## Engineers Comments Regarding Surface Water Drainage

<b>Application Reference:</b>	BN/125/25/PL	<b>Reviewer Reference:</b>	ADC/EXT4b
<b>Planning Officer:</b>	Amber Willard	<b>Date of Review:</b>	26/01/2026
<b>Site Name:</b>	Land South of The Hollies 84 Barnham Road Eastergate PO22 0ES		
<b>Application Description:</b>	Construction of 2 No. dwellings (C2 Residential Institutions), in association with the Hollies, and associated works. This application affects the setting of a listed building and is in CIL Zone 2 and is CIL Liable as new dwellings.		
<b>Assessment Number:</b>	1 of 2

Drawing title: **Proposed
Block Plan**

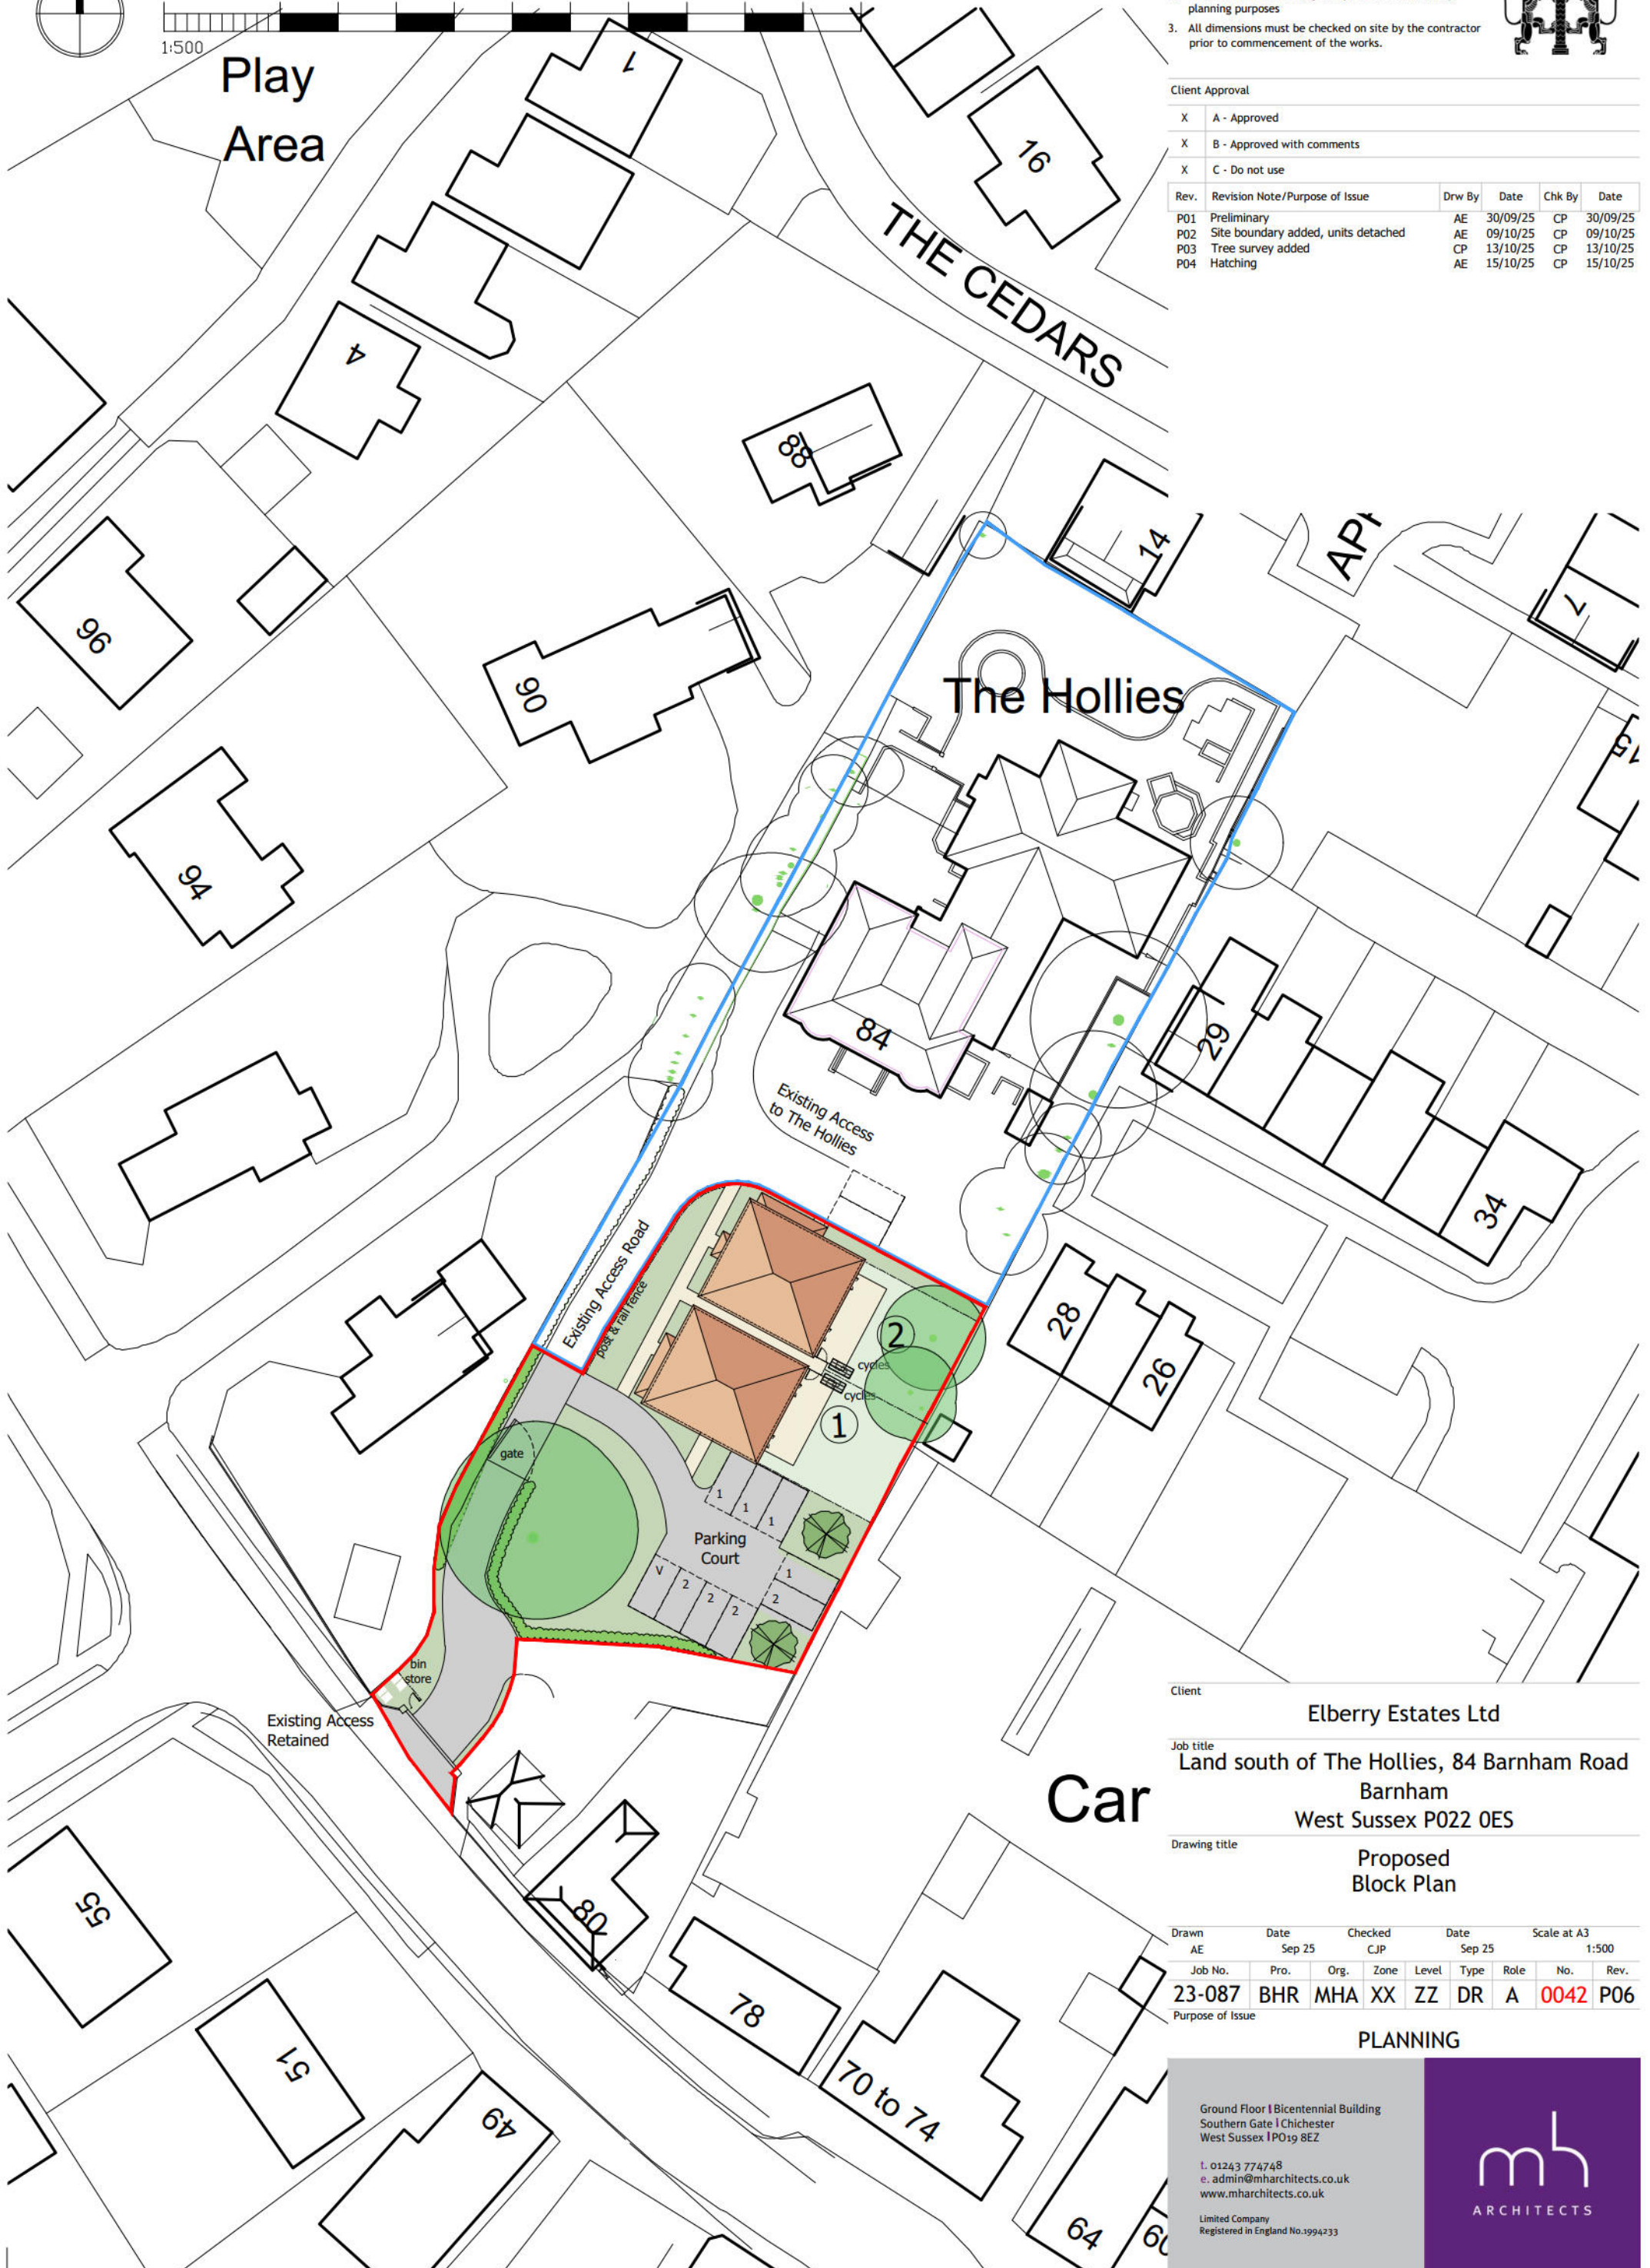
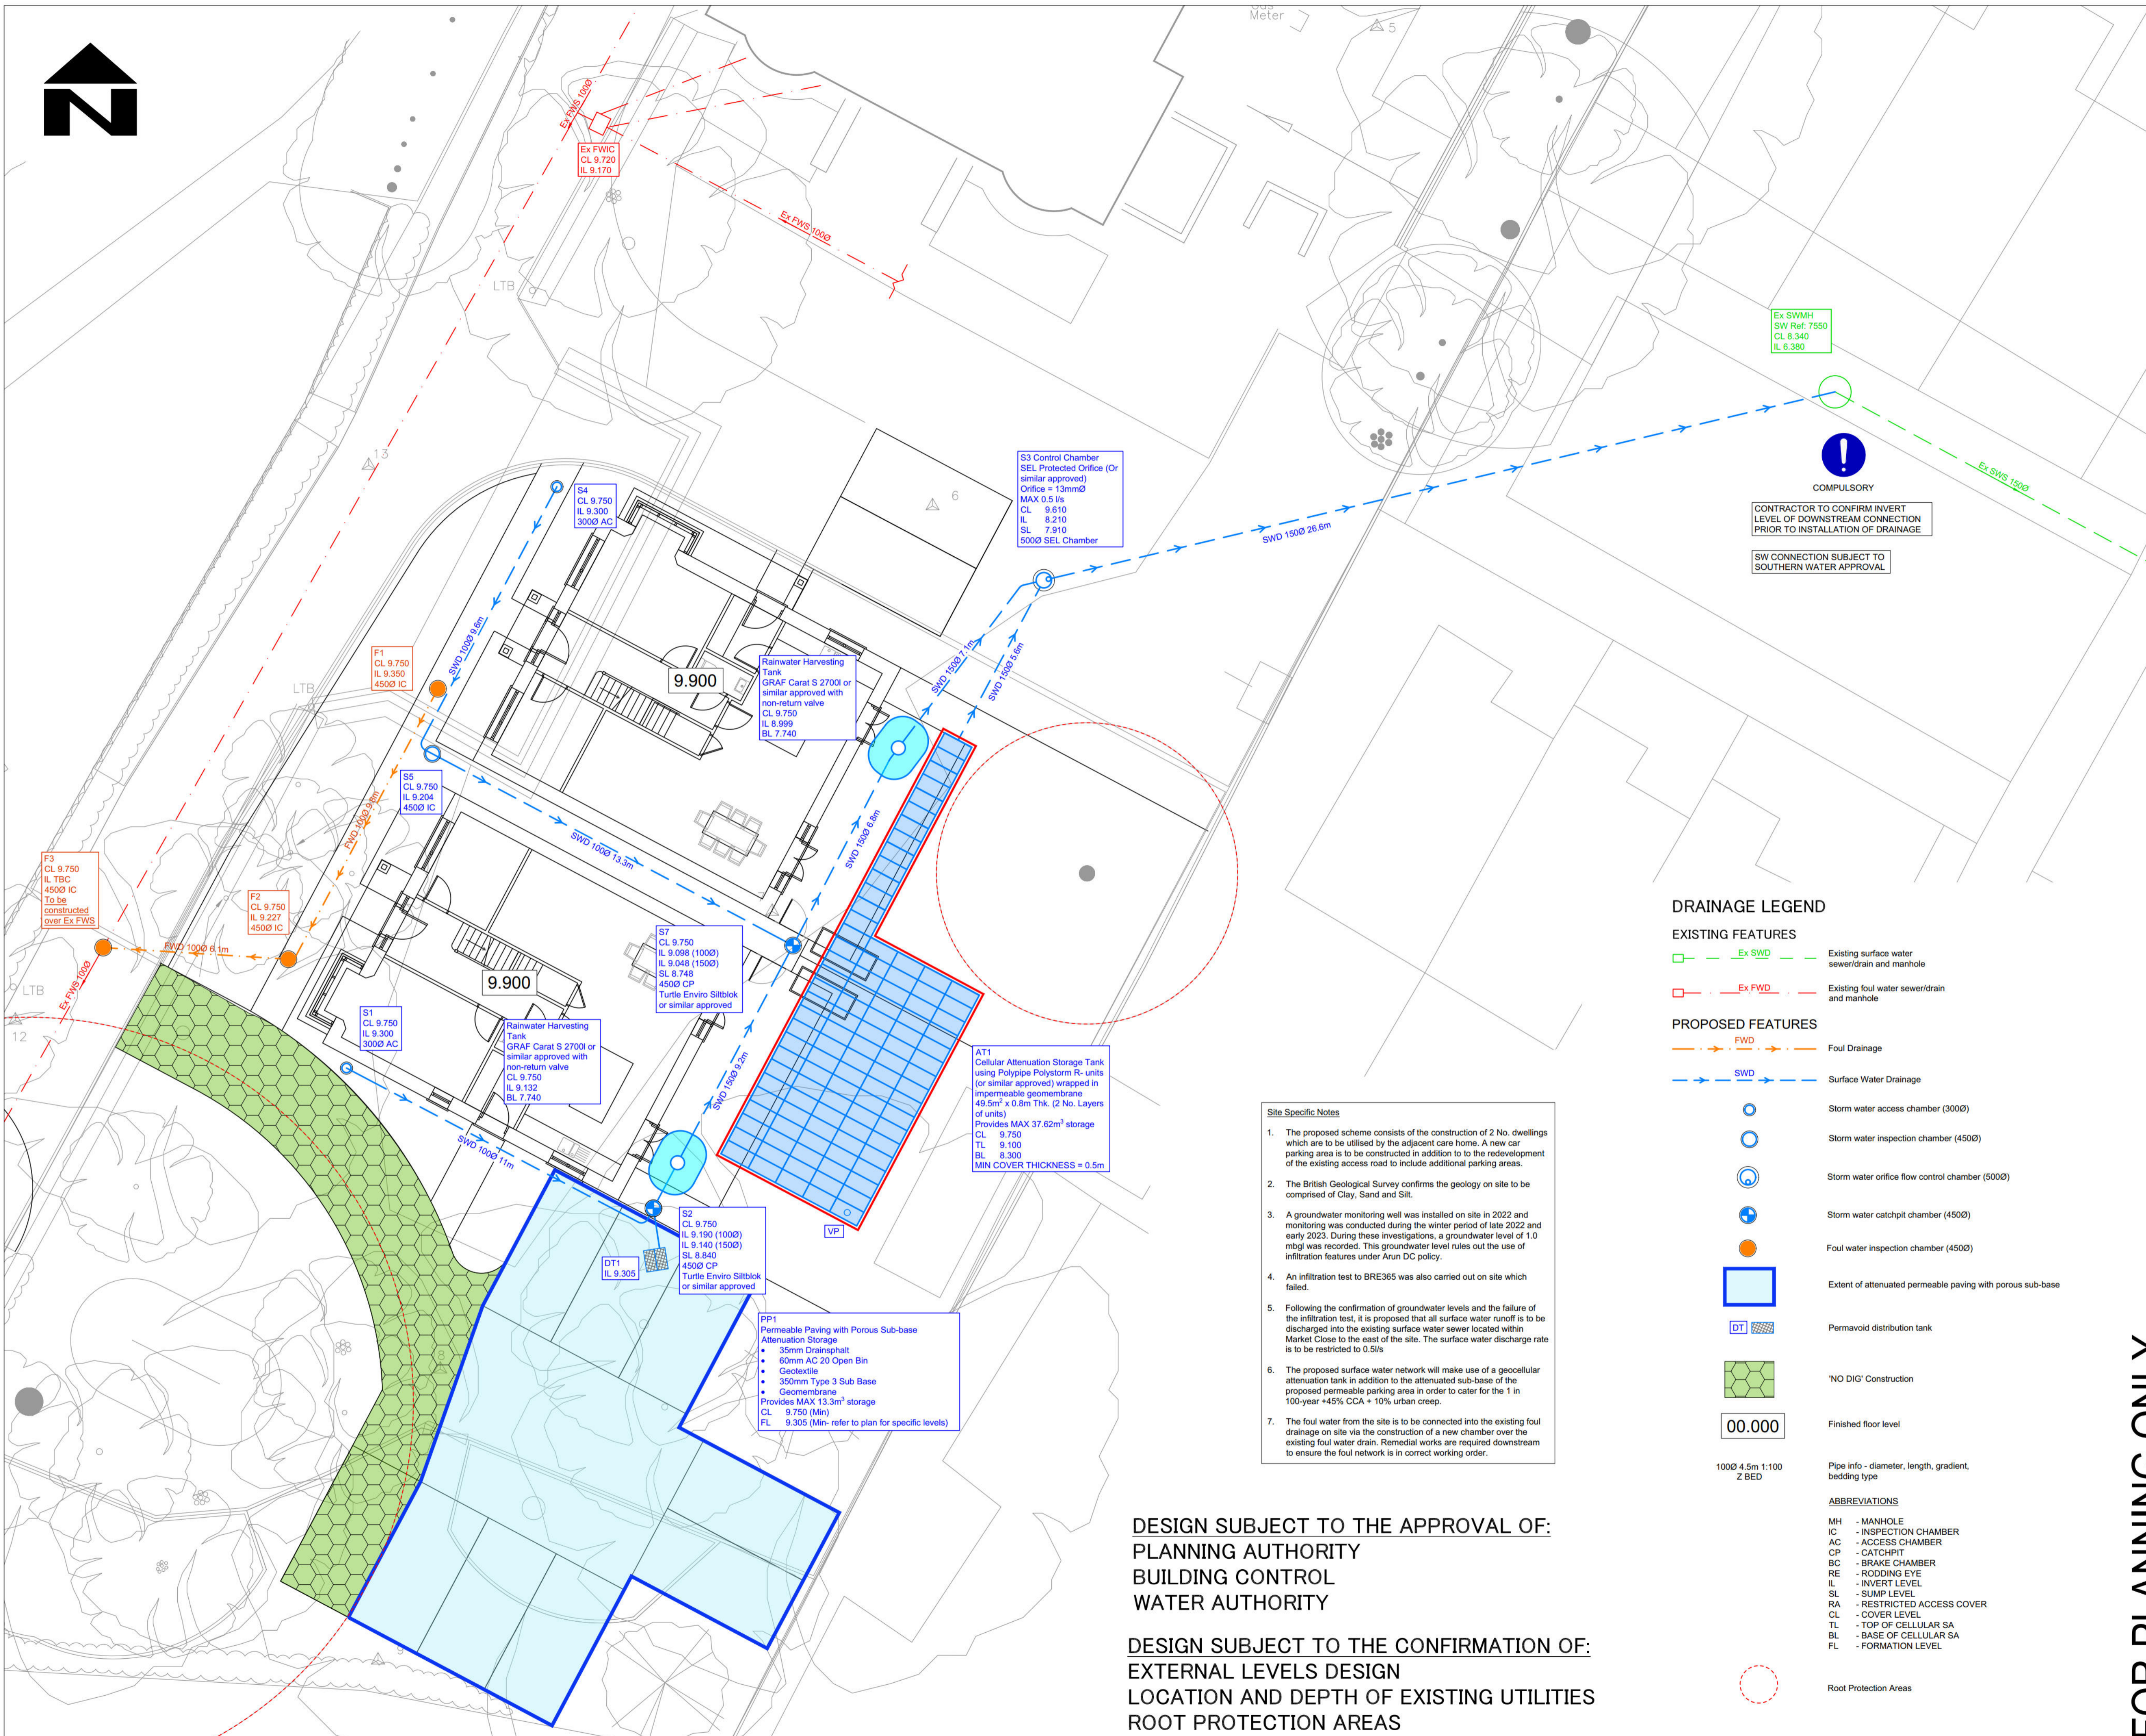
7. Construction, operation, maintenance, decommissioning and structural integrity
- 7.1. A tree which is the subject of a tree preservation order (TPO) is present in the southwest of the site. The access to the parking area skirts the root protection zone (RPZ) of this tree, with no-dig construction proposed. There are no pipes within the RPZ of this or any other significant tree and the contributing area of the no-dig drive is accounted for in the design.
